Recommendation Report for Planning Permission for Works or Extension to a Dwelling

REF NO: AW/114/22/HH

LOCATION: 11 Hughes Close
Aldwick
PO21 5RU

PROPOSAL: Erection of single storey side and rear extension including linking garage to the house.

Proposed Extension and Alterations
at 11 Hughes Close, Bognor Regis
for Mr and Mrs C Parker
Drawing P02 April 2022 Scale 1:100 / 1:500 @ A3
Planning Drawing - Roof Plan, Elevation & Block Plan

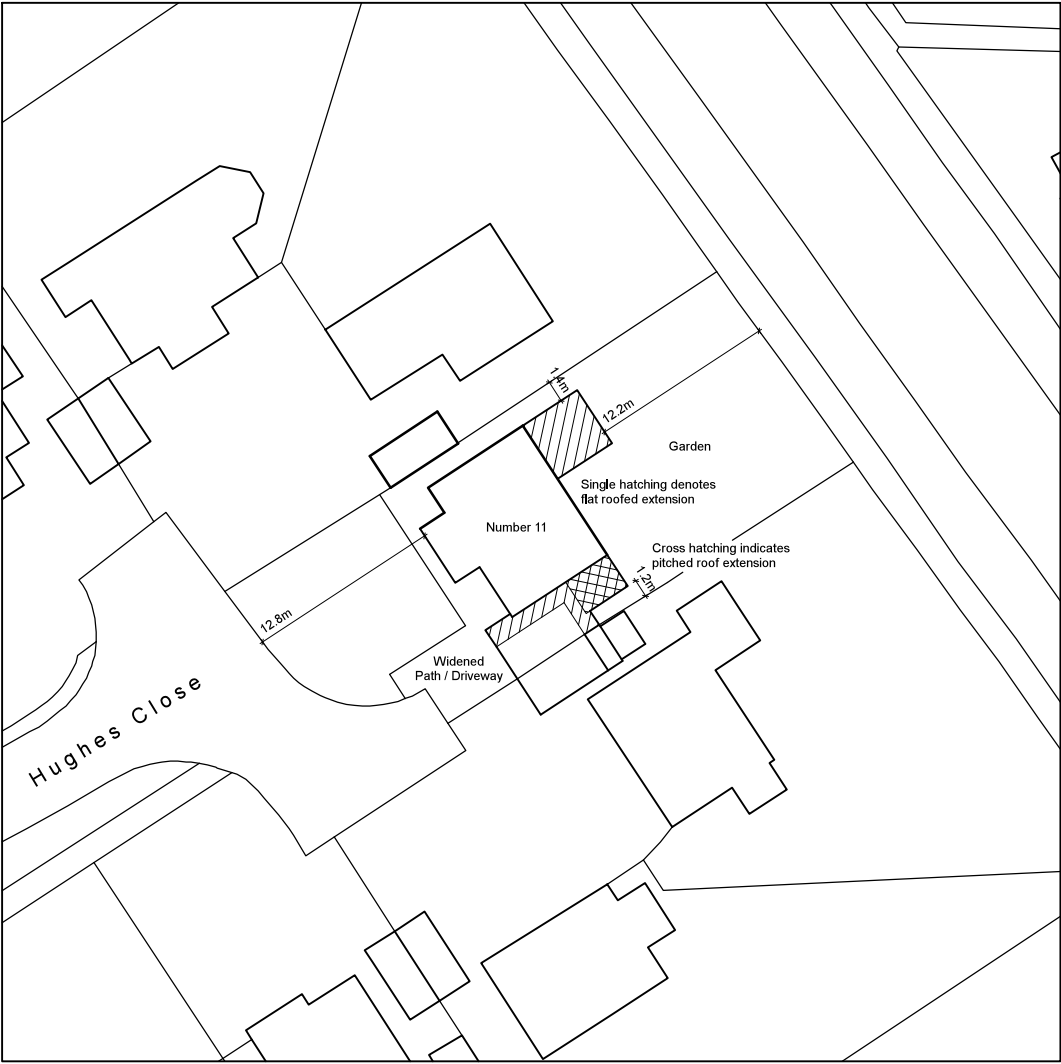
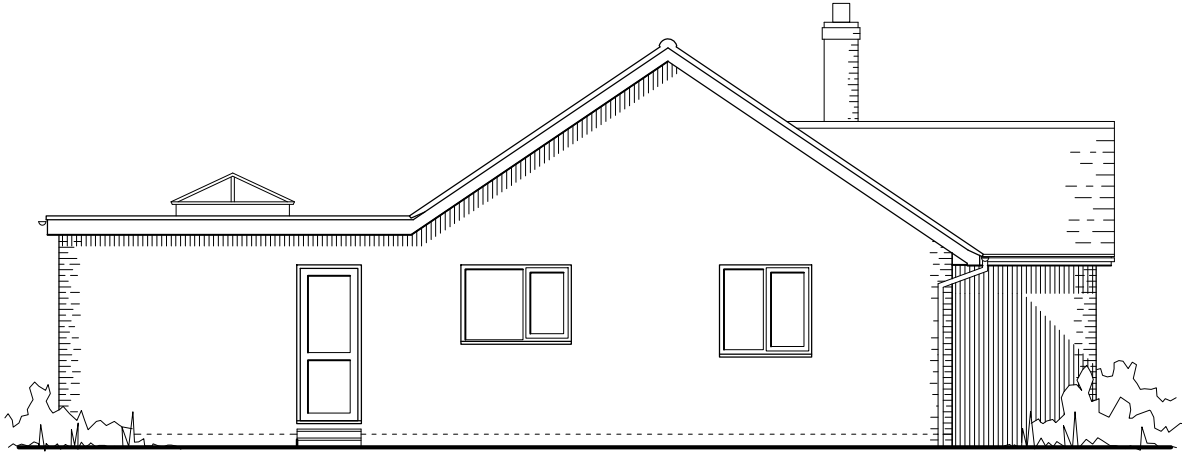
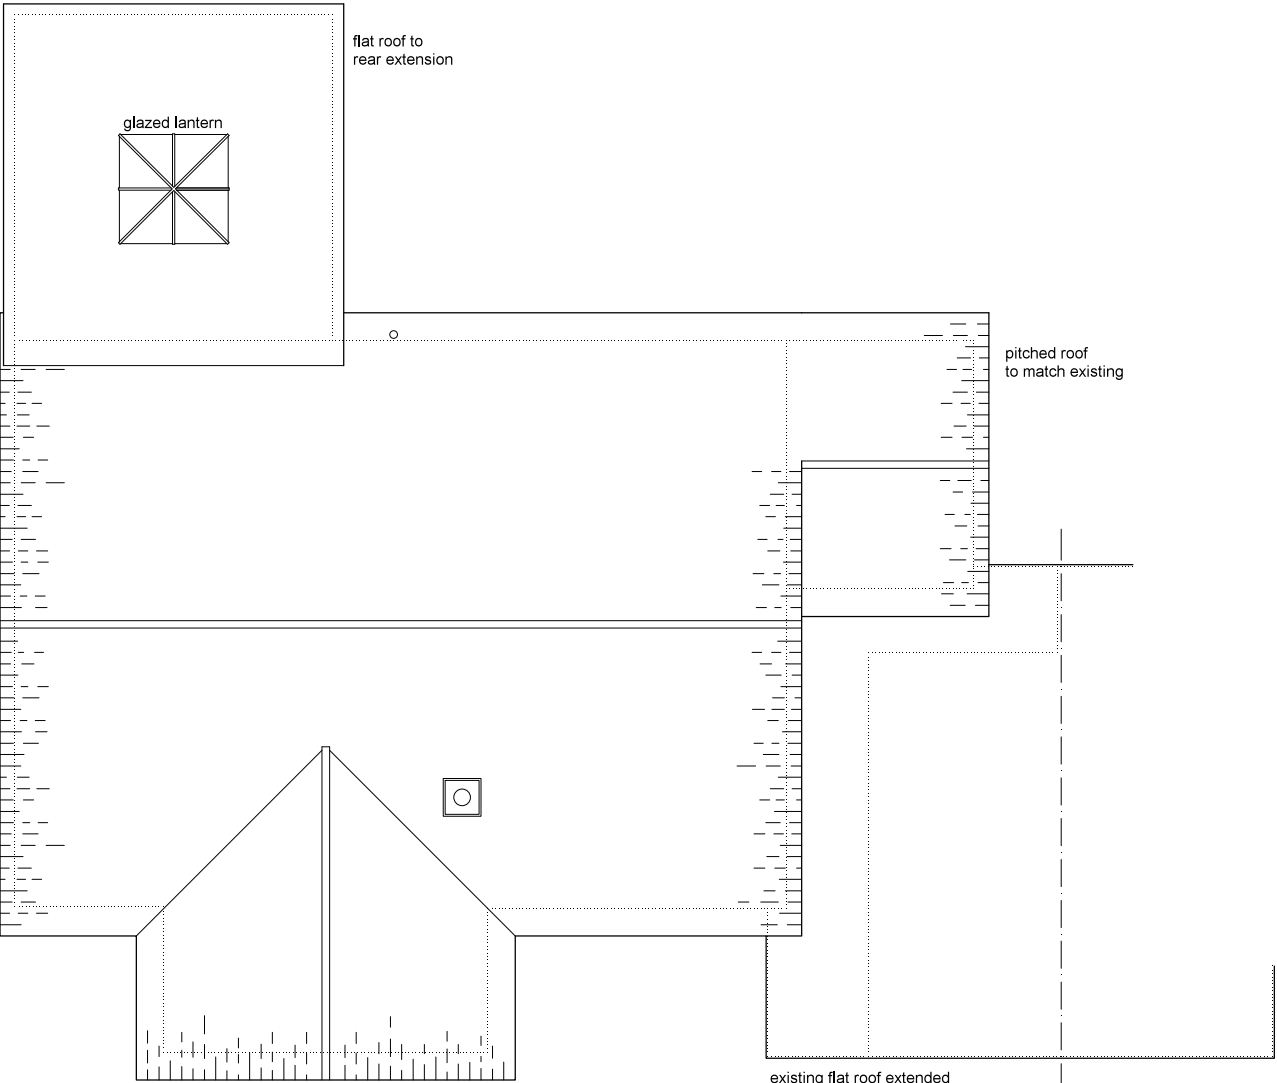
The rear extension will project 4.3m from the rear wall, with a width of 4.2m. It is a modest size and will have a flat roof similar to that of the garage. This differs to the gable roof of the host but will not appear unduly out of place and is acceptable. It is in keeping with the character of the property and will have minimal impact on its visual appearance and amenity.

The side extension is the only part of the proposal which will be visible from the street. Despite being visible, the enlargement of the garage is the only part of the side extension that can be viewed from the front, and as such the impact on the street will be minimal. It will have little harm on the composition and appearance of the street, in that the principal elevation will not look significantly different to the existing and remains in keeping with the character of the area.

The extensions will be single storey and incorporate flat and gable roofs. The rear extension will have a flat roof, measuring approximately 3.03m high. It will include a roof lantern which will protrude higher at a height of 3.6m, and of which will have no adverse impact on residential amenity. The side extension will include a flat roof and gable roof. The flat roof will match up with the existing and neighbouring garage, at approximately 2.35m high. The gable roof will be 3.93m high, and 2.52m at the eaves. The proposal will retain a minimum of 1.4m to the north boundary, 12.2m to the east (rear), and 1.2m to the south. These accord with D DM4 of the Local Plan, and are acceptable, posing no risk of adverse harm to residential amenity. Neither extension conflicts the 45 or 60-degree rules, and there will be no resulting unacceptable overbearing or overshadowing of neighbouring properties to either side.

Drawing P01 April 2022 Scale 1:100 / 1:1250 @ A3  
Planning Drawing - Floor Plan, Elevations & Location Plan

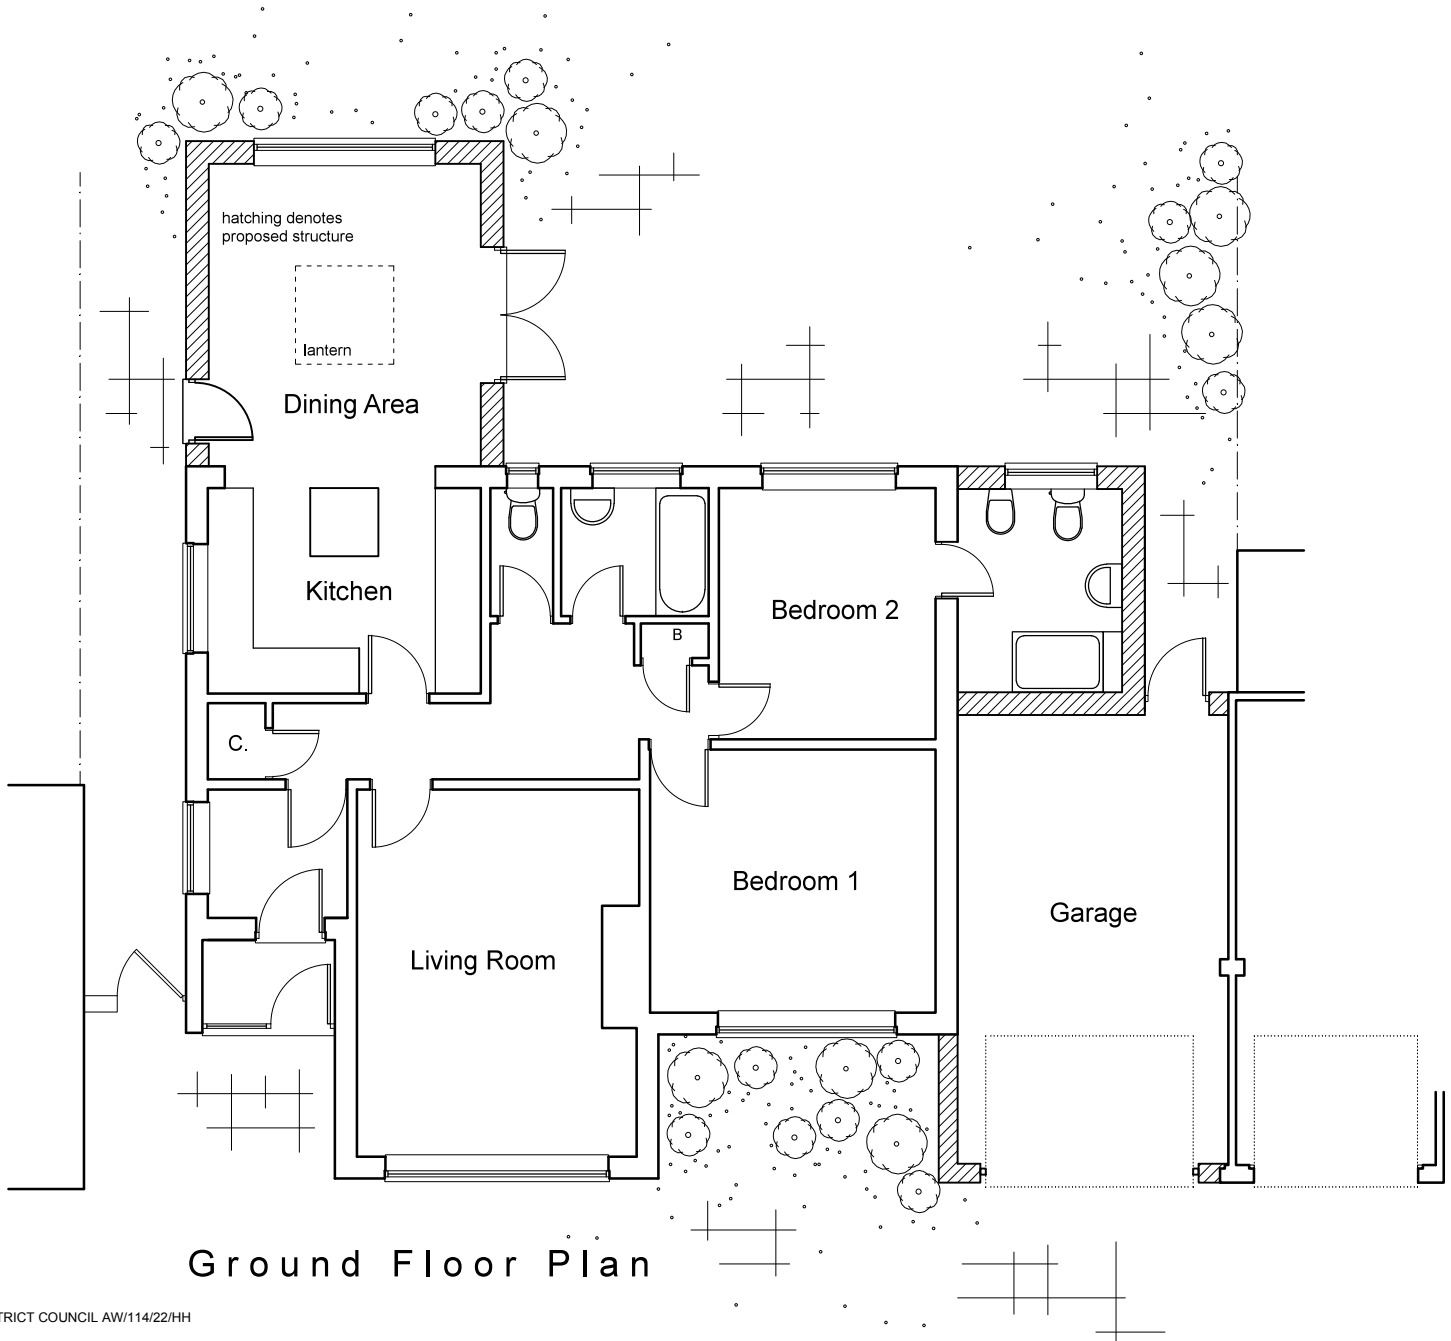
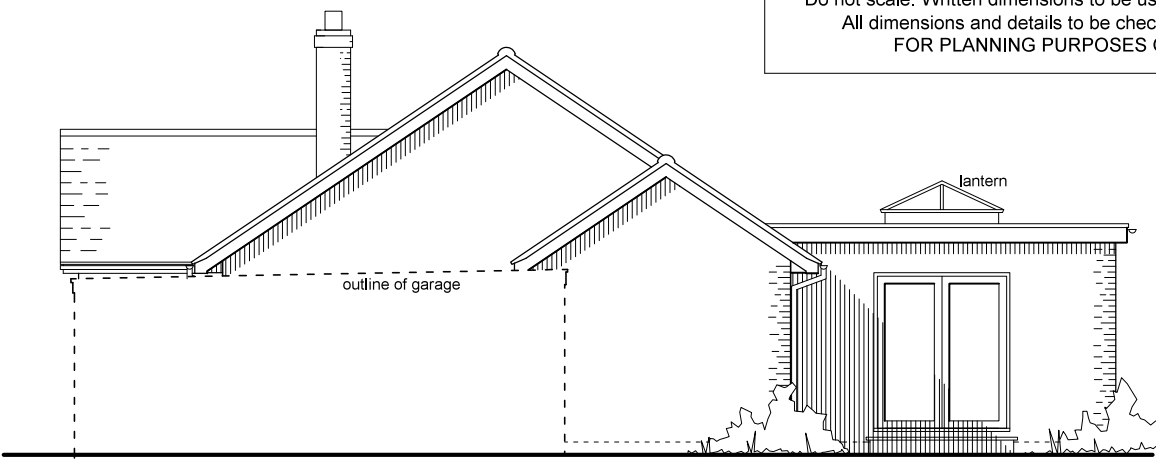
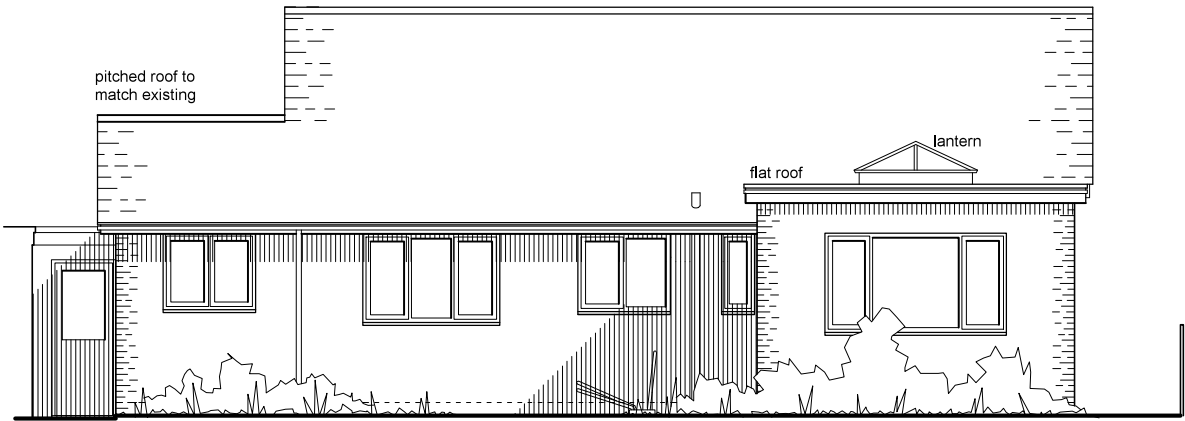
The proposal will consist of two single storey extensions, one to the side and other to the rear. The side extension will include the enlargement of the detached garage, linking it to the main dwelling, and construction of a small extension to the rear of this garage. The enlarged garage will measure 3.85m deep and 6.5m wide, with the smaller side extension measuring approximately 2.46m deep and 2.98m wide. The garage aspect will have a flat roof, matching the height of the existing garage, and mirroring the style of the attached neighbouring garage to the south. The other extension will have a gable roof, smaller in height but matching the pitch and design of the host dwelling. Both will integrate sympathetically with the existing and have no adverse harm on the visual appearance or character of the property, retaining the established design style of the dwelling.

In addition to the roof lantern, the rear extension features a single door to the north elevation, window to the east, and French doors to the south. None of these features will result in adverse overlooking of neighbouring properties, with the majority facing the garden. They will not be unduly harmful to residential privacy or amenity and are acceptable. The side extension includes a new garage door to the west (front) elevation, and a single door and window to the east elevations. The garage door will face towards the street and result in no overlooking of neighbouring properties. The features to the east will overlook the garden and pose no risk of harm to residential privacy or amenity.
